Project # 1007017

Project Name: SUNPORT PARK

Date: June 24, 2008
To: Jack Cloud, DRB Chair
From: Carol Toffaleti, Planner, Development Review, 924-3345
cc: Alfredo Barrenechea, NMHCR LLC
Subject: Project # 1007017 – 08EPC 40005 Master Development Plan, 08EPC 40006 Site Development Plan for Building Permit – Woodward Rd. SE

**Site Plan for Building Permit**  
 Lot 2-A-3, Block 2, Sunport Park Subdivision  
 Albuquerque, New Mexico

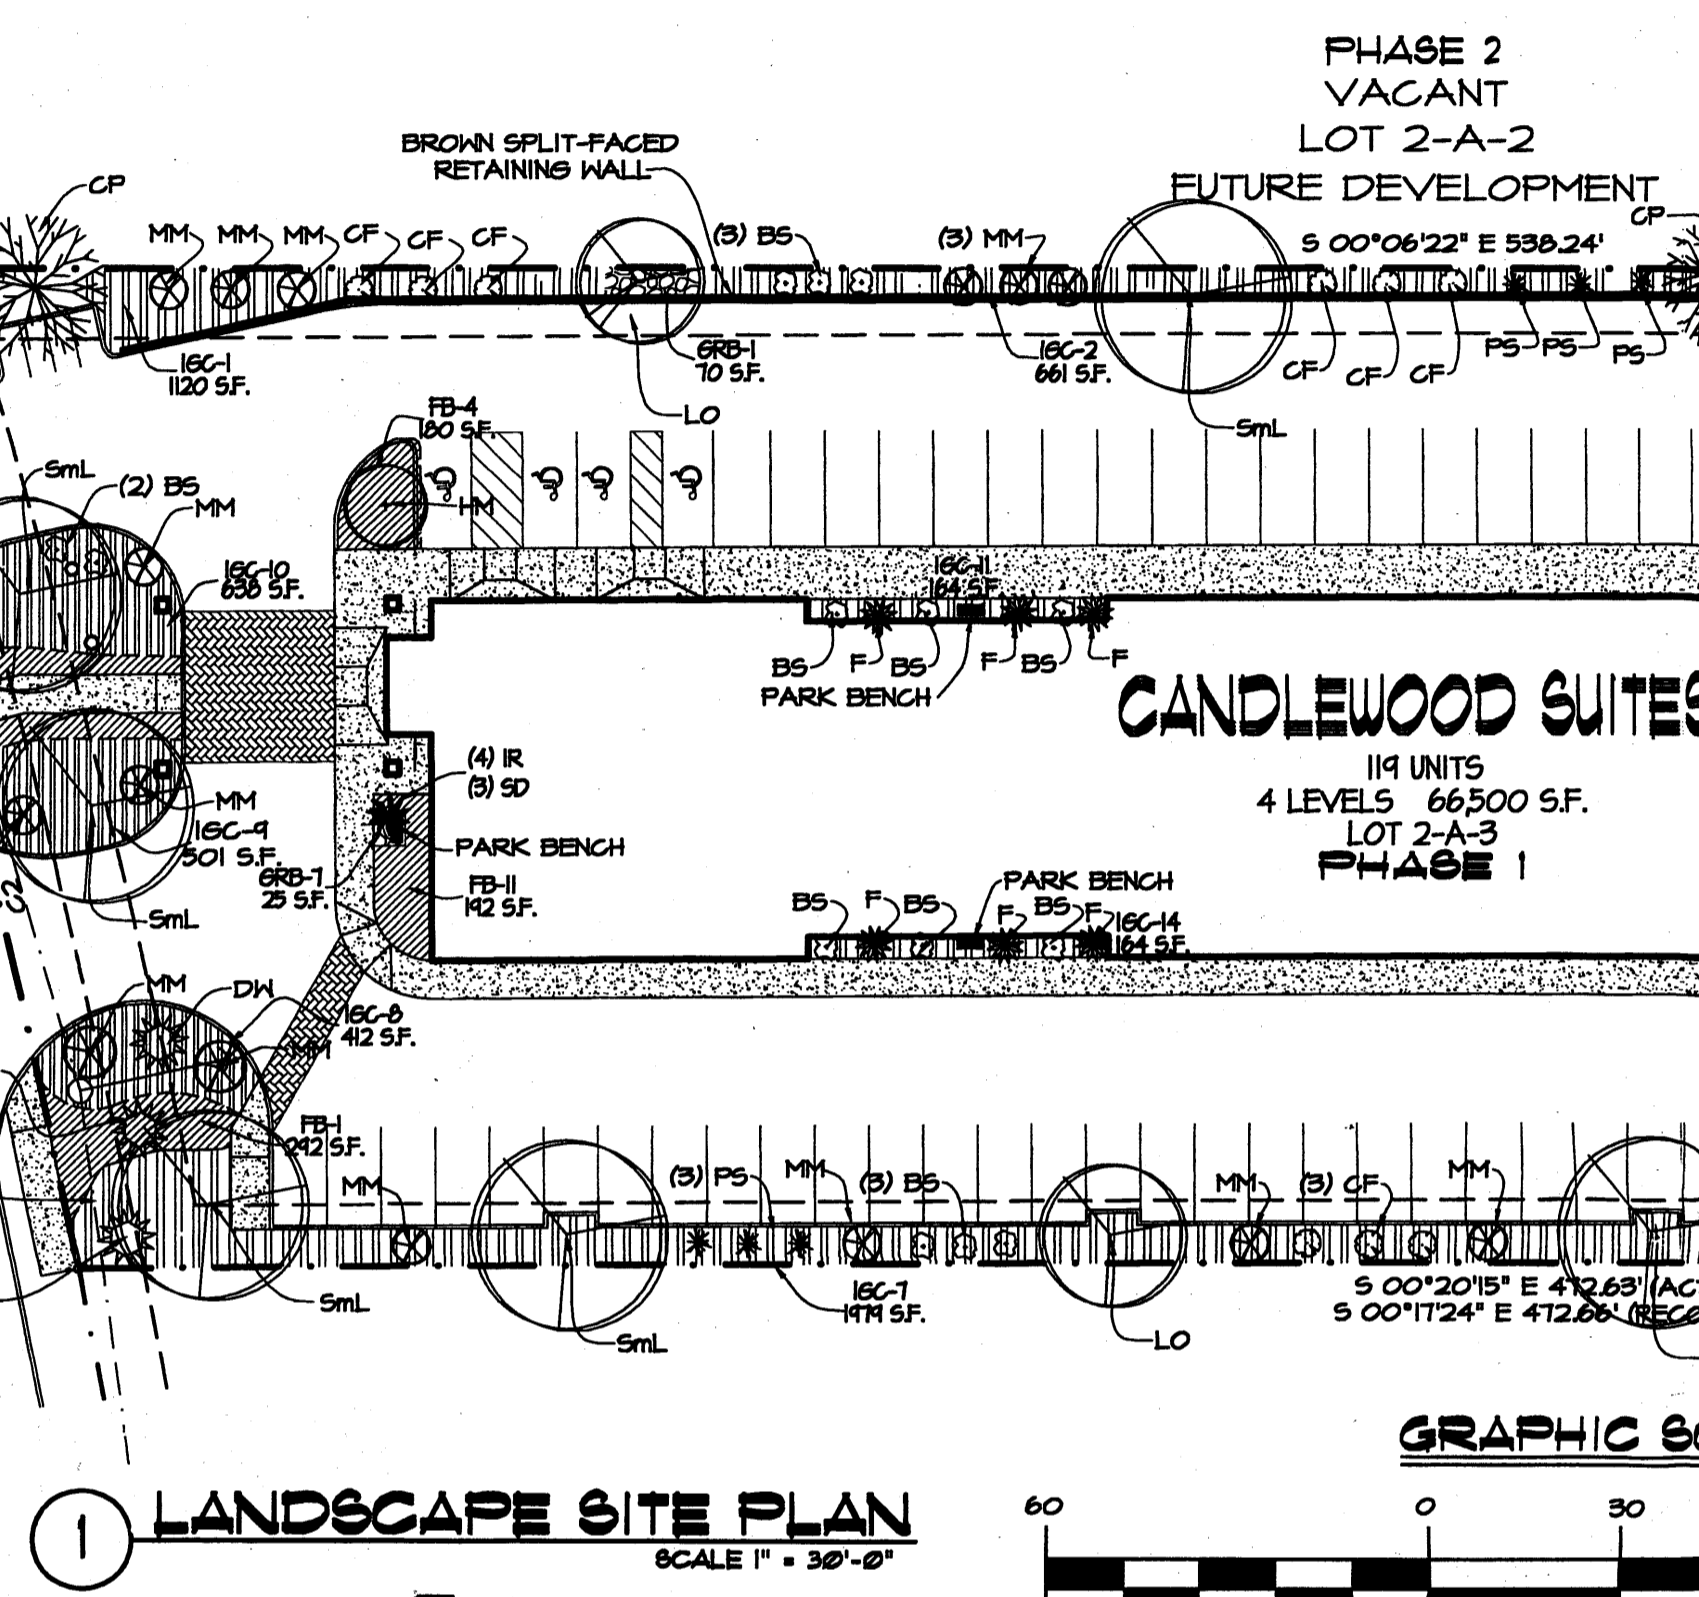
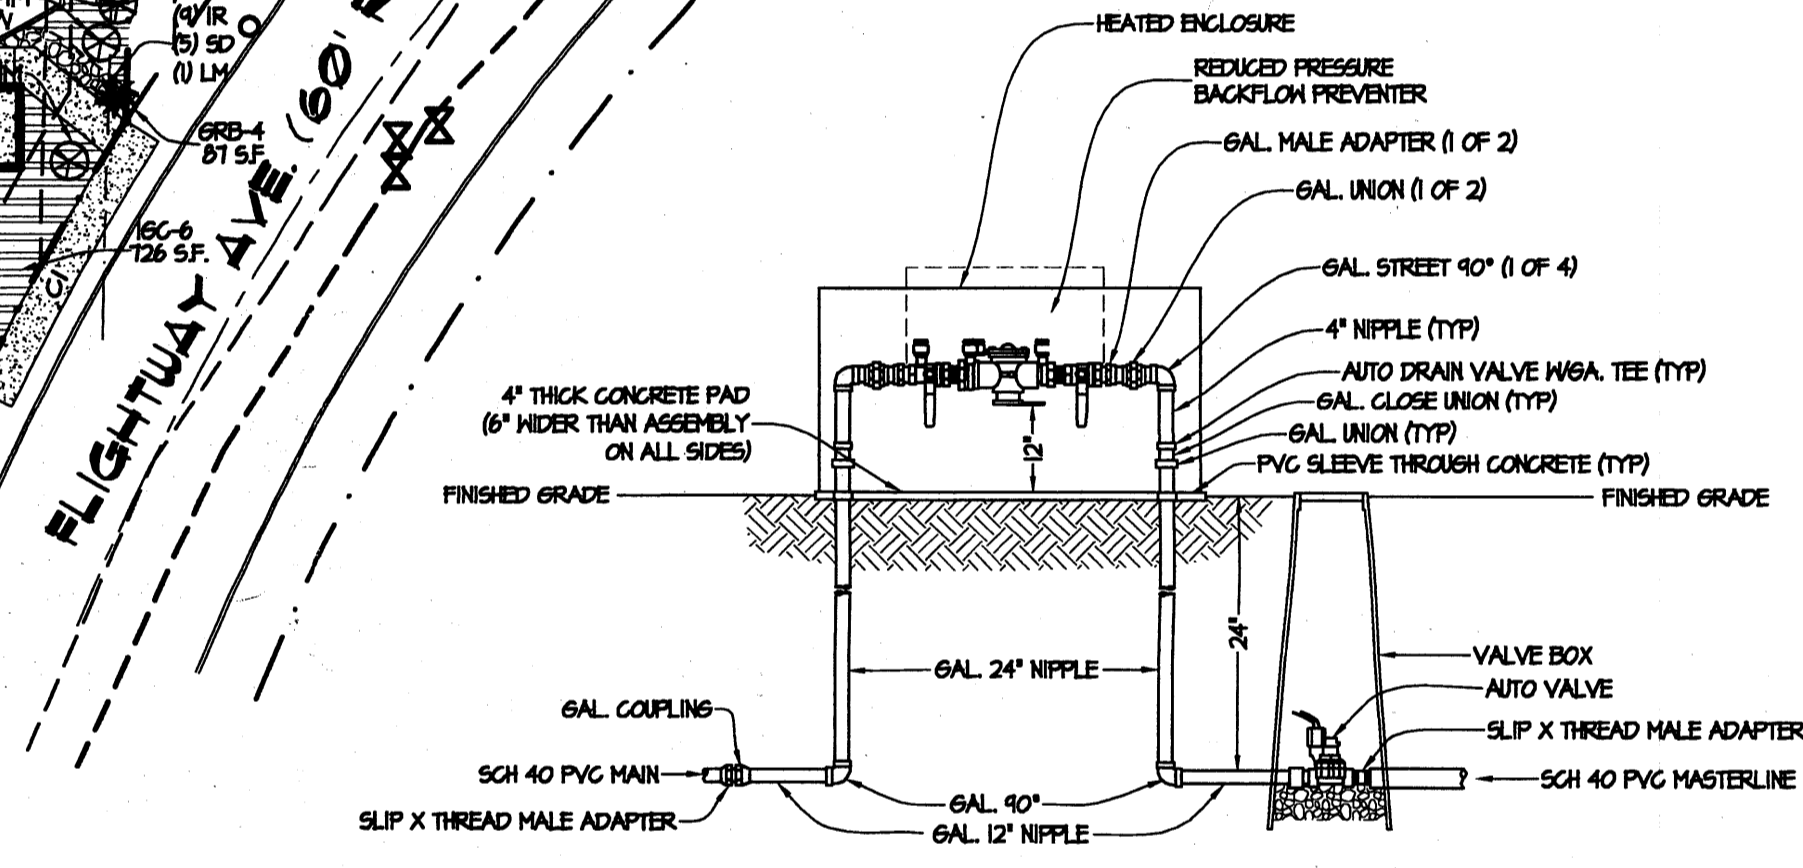
#21 Landscape plan:

The following errors in the plant list need correcting:

**Site Plan for Building Permit**  
 Lot 2-A-3, Block 2, Sunport Park Subdivision  
 Albuquerque, New Mexico

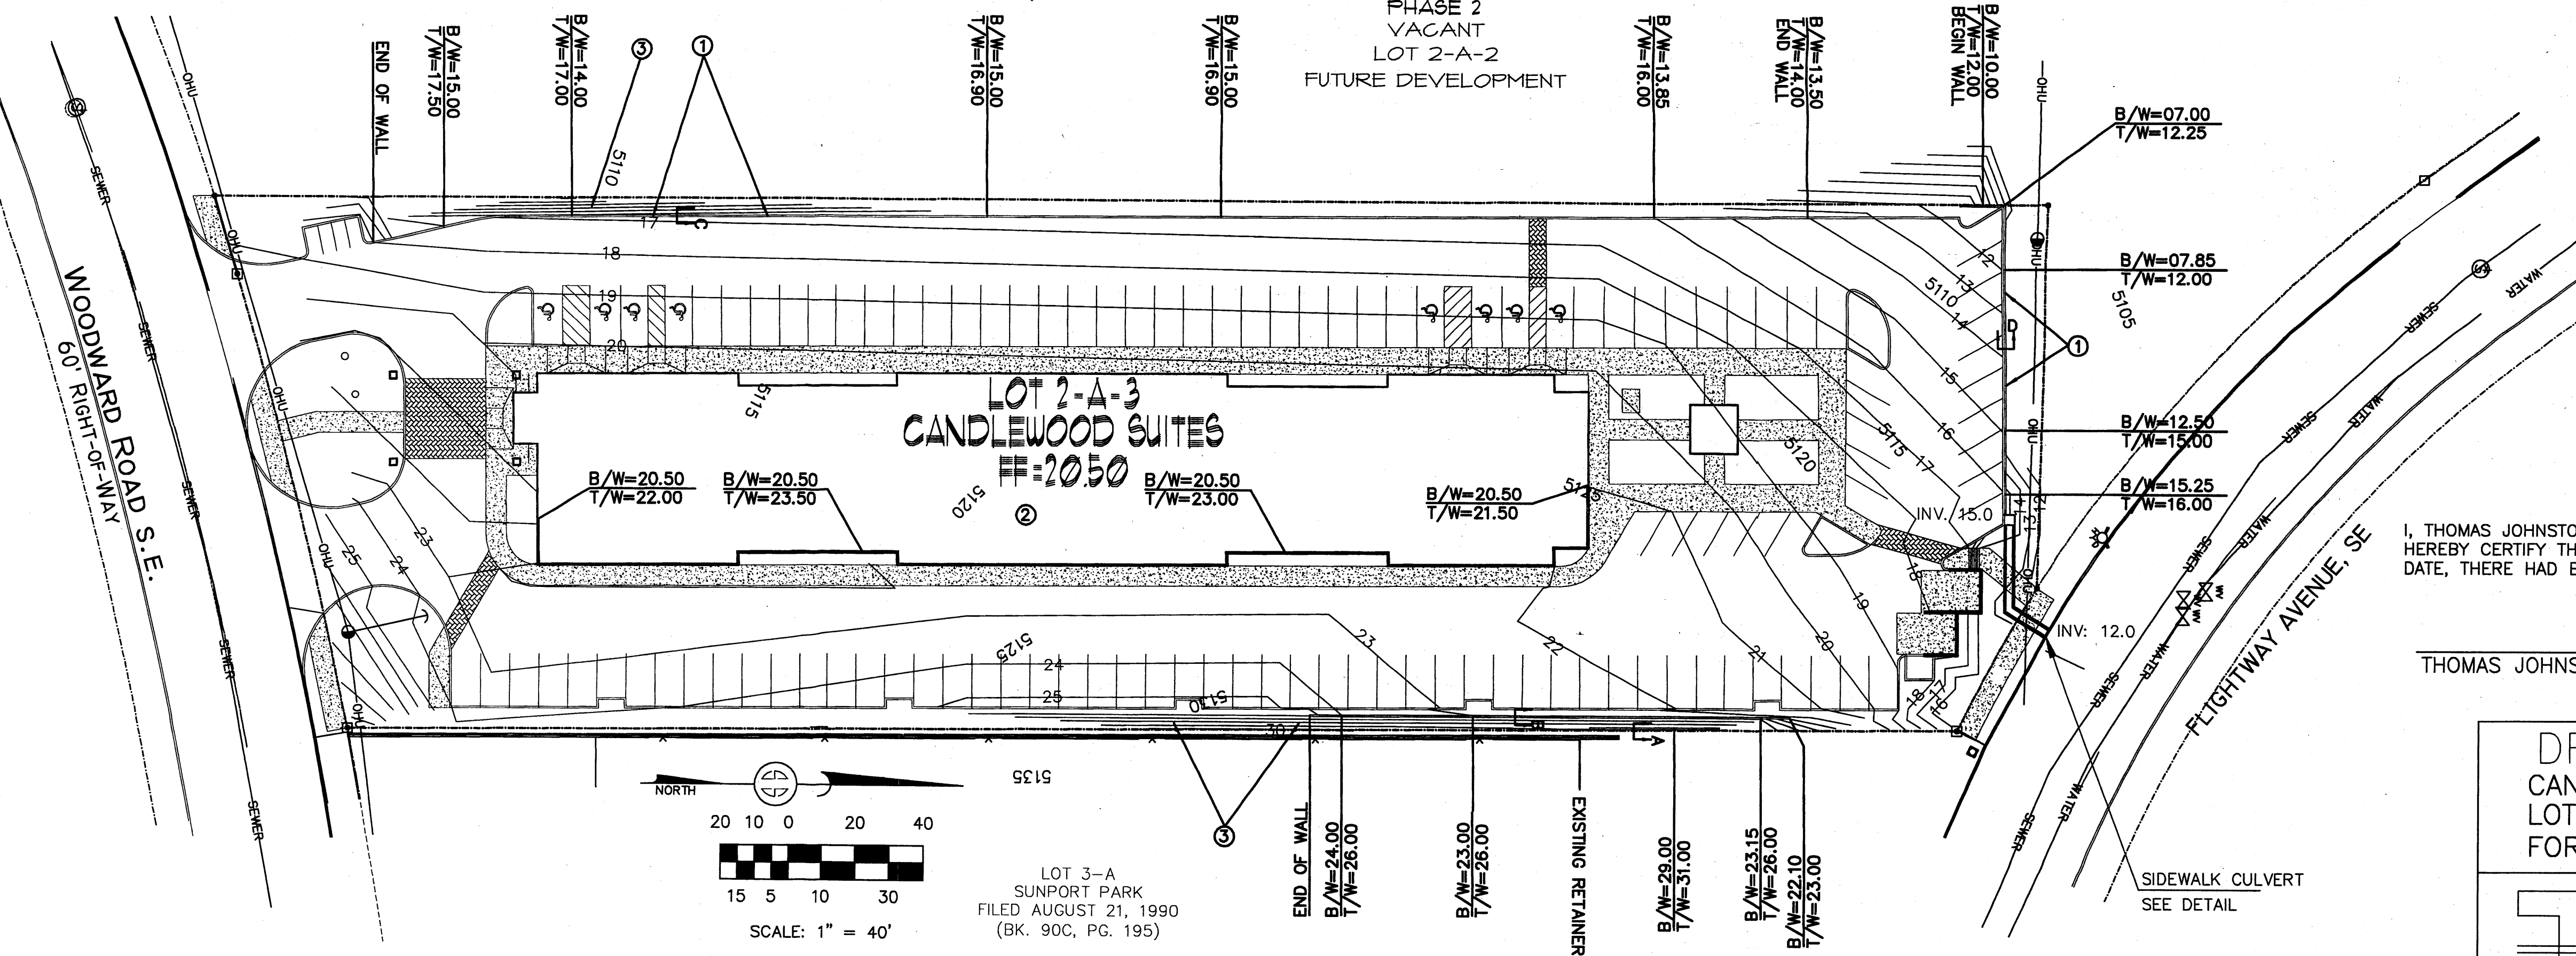
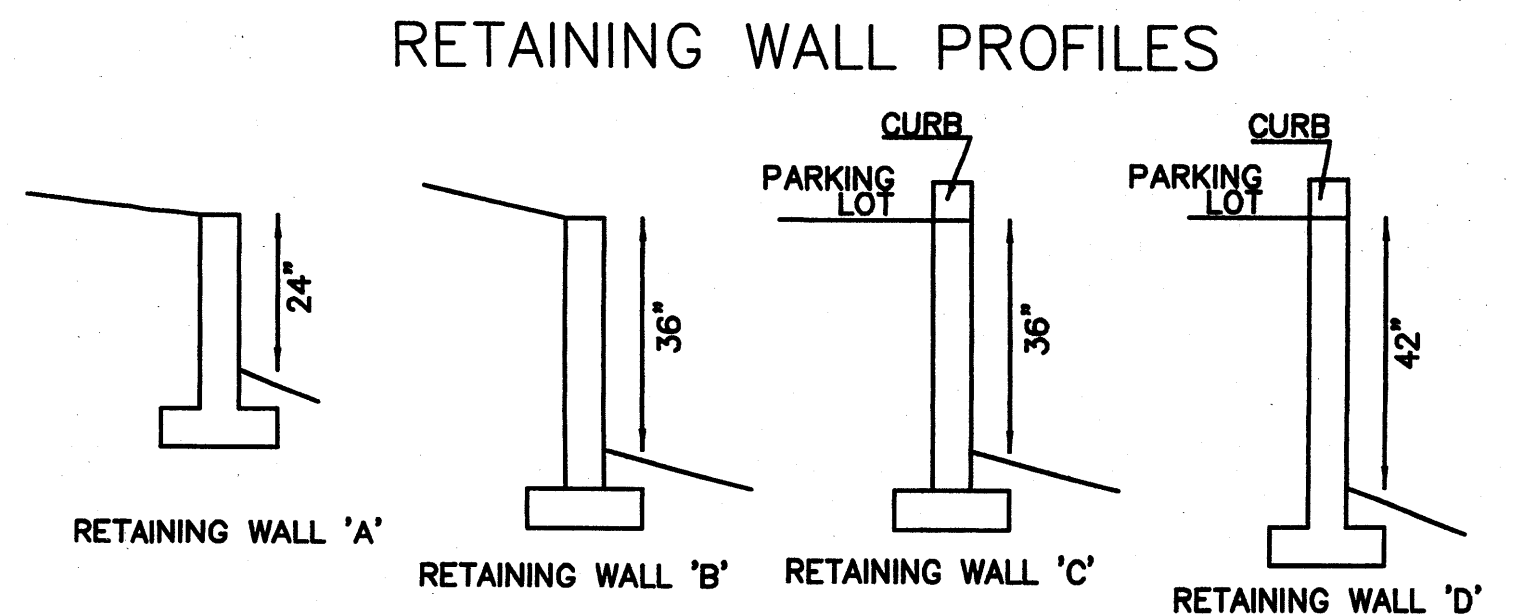
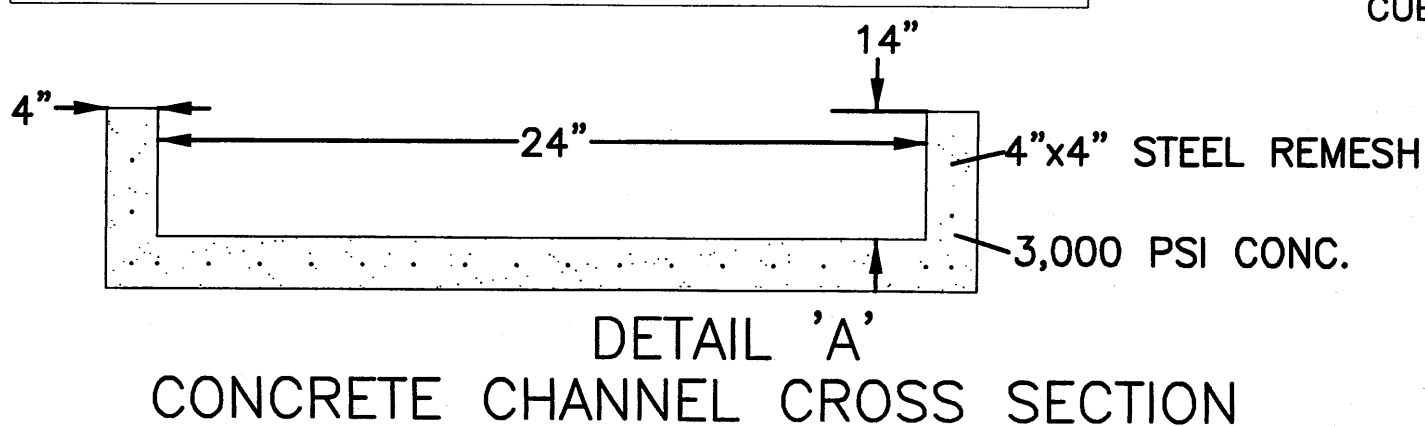
Grading & Drainage Plan – The drainage data is illegible.
